From: Martyn White
Sent: 20 November 2018 10:13
To: Anita Gardner
Subject: CM/26/18/L

CM/26/18/L

The application seeks to undertake sympathetic works to the roof of the Mill. Further it also proposes to undertaken a small section of rebuilding to the northern gable to enable roof to be reinstated over exposed verges; as well as specific repointing where brickwork is defective; repointing of chimney stacks using the correct mortar.

Copyright 2017 Gary Love

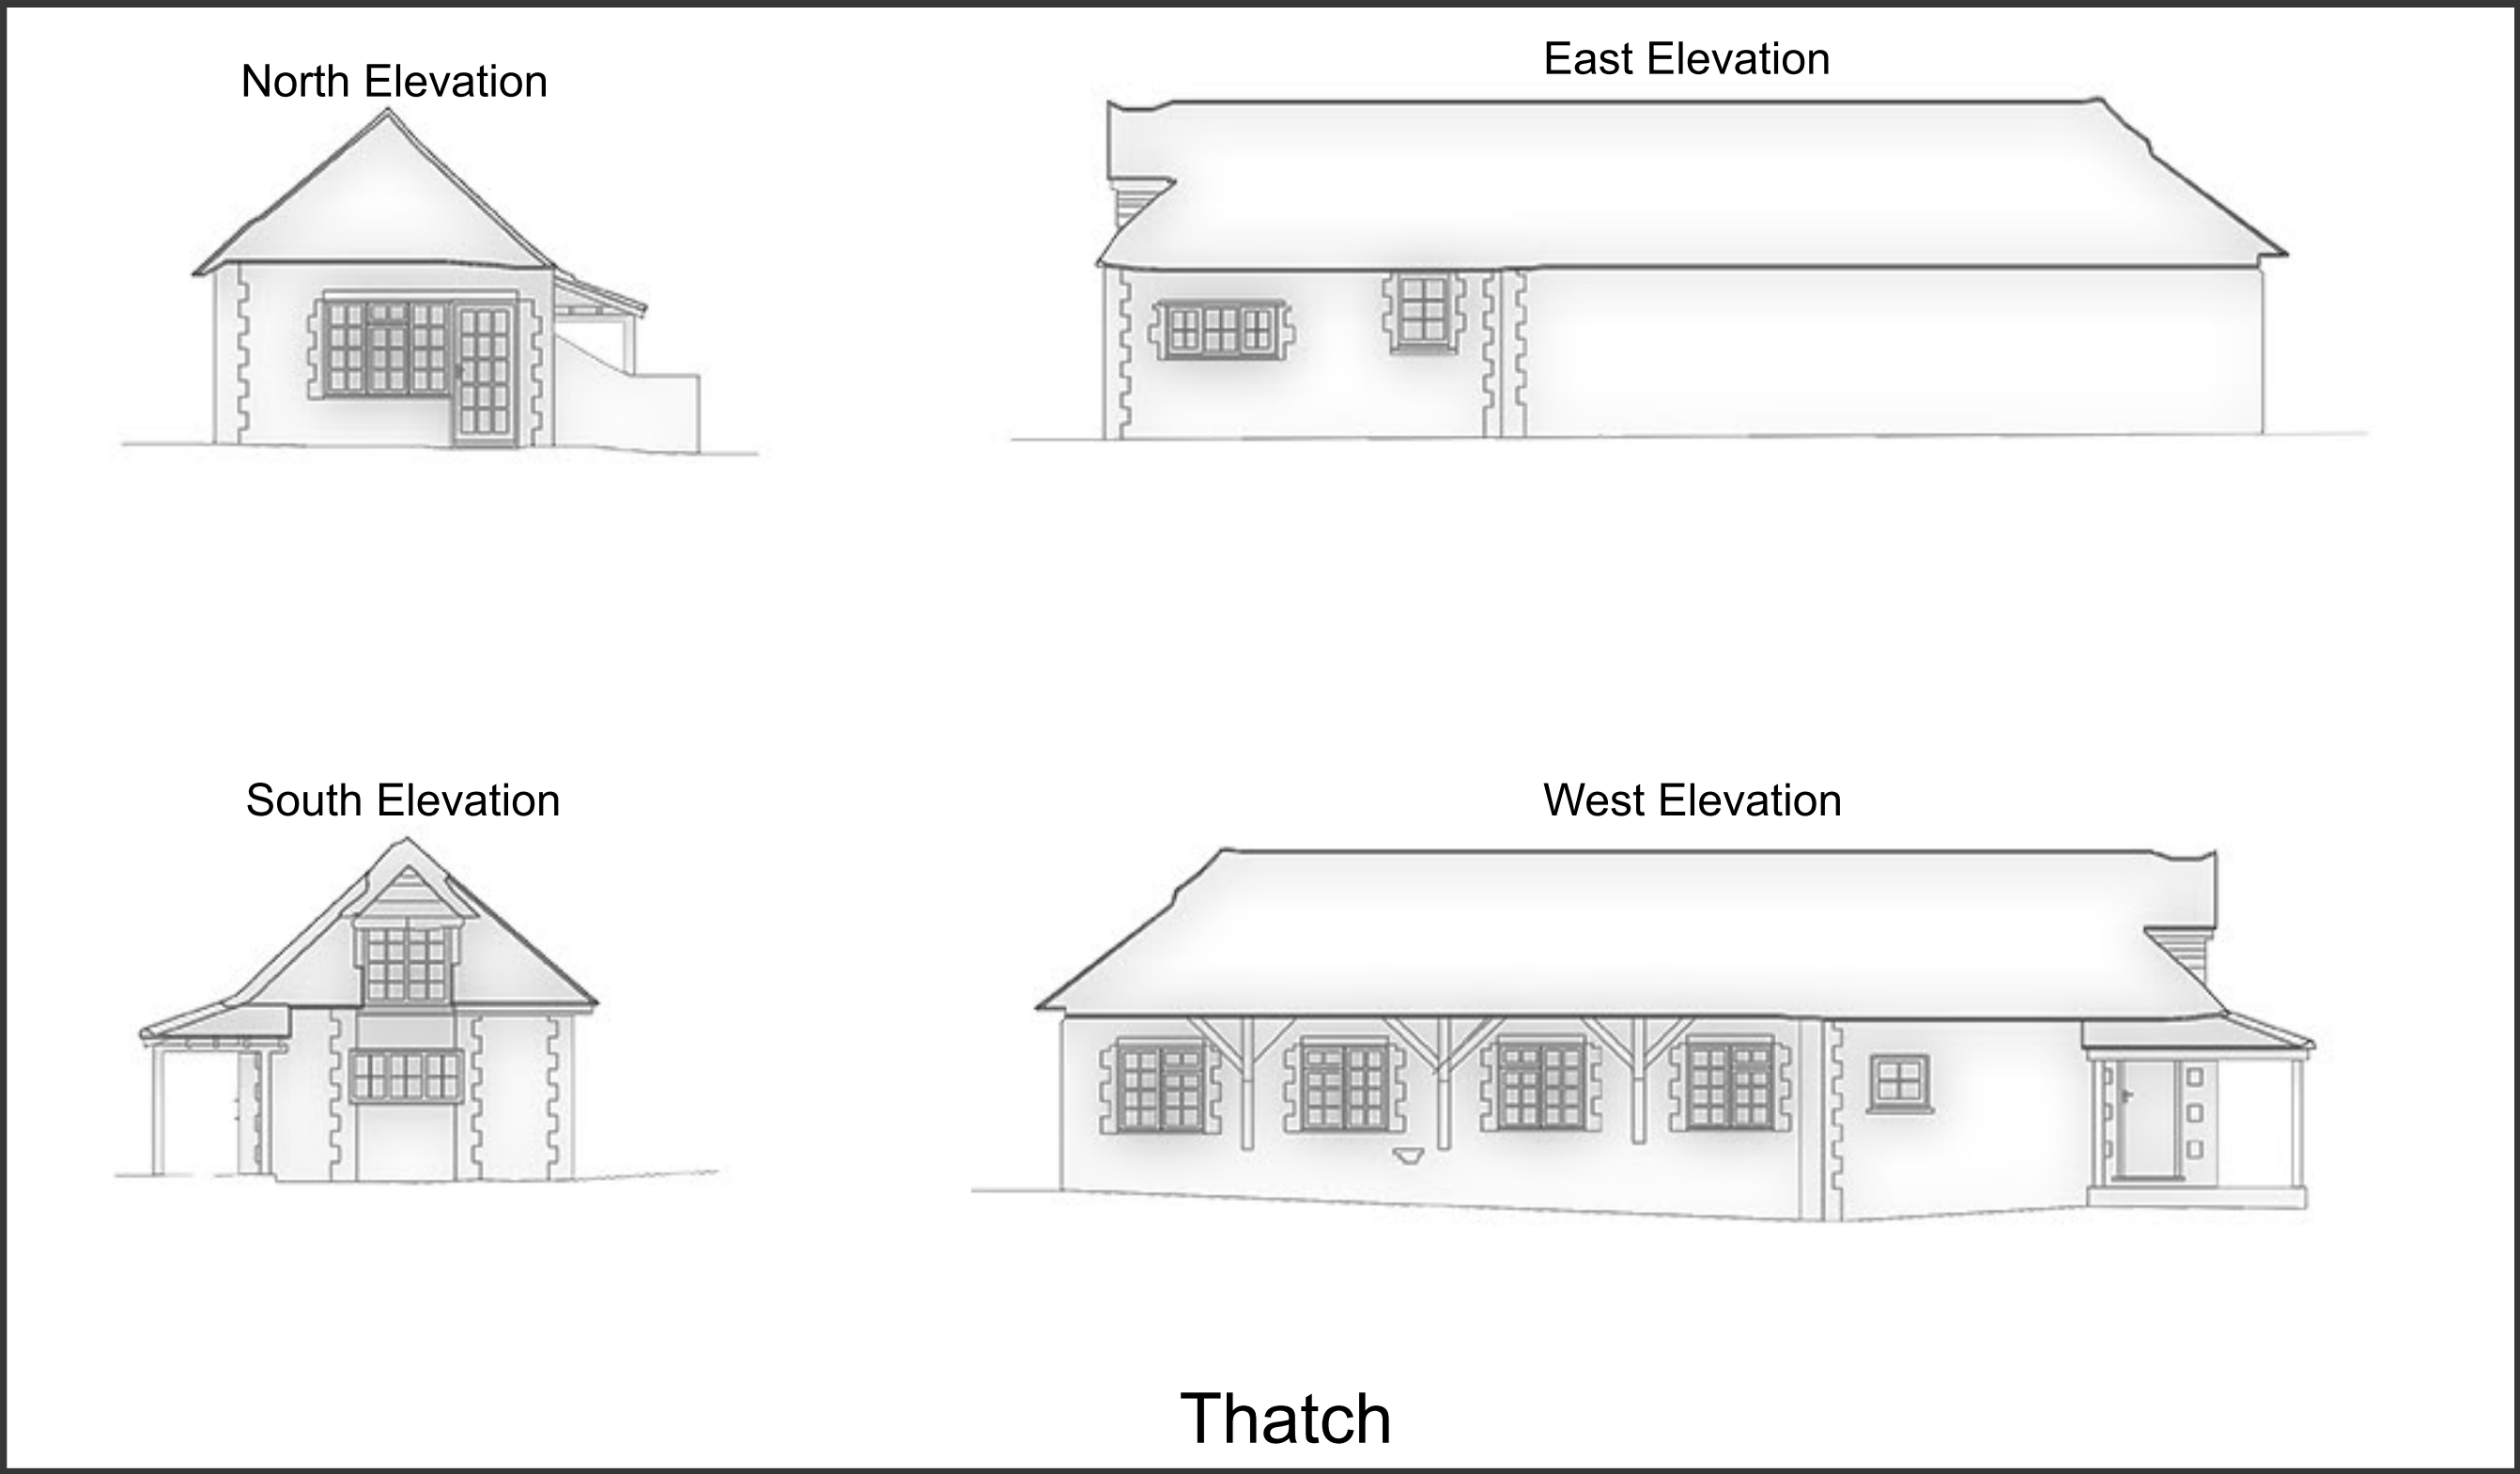
You may wish to condition the details of the slate/clay tile, along with the replacement rainwater goods, and details of the works to the northern gable which will extend the roof to cover the exposed flint wall.
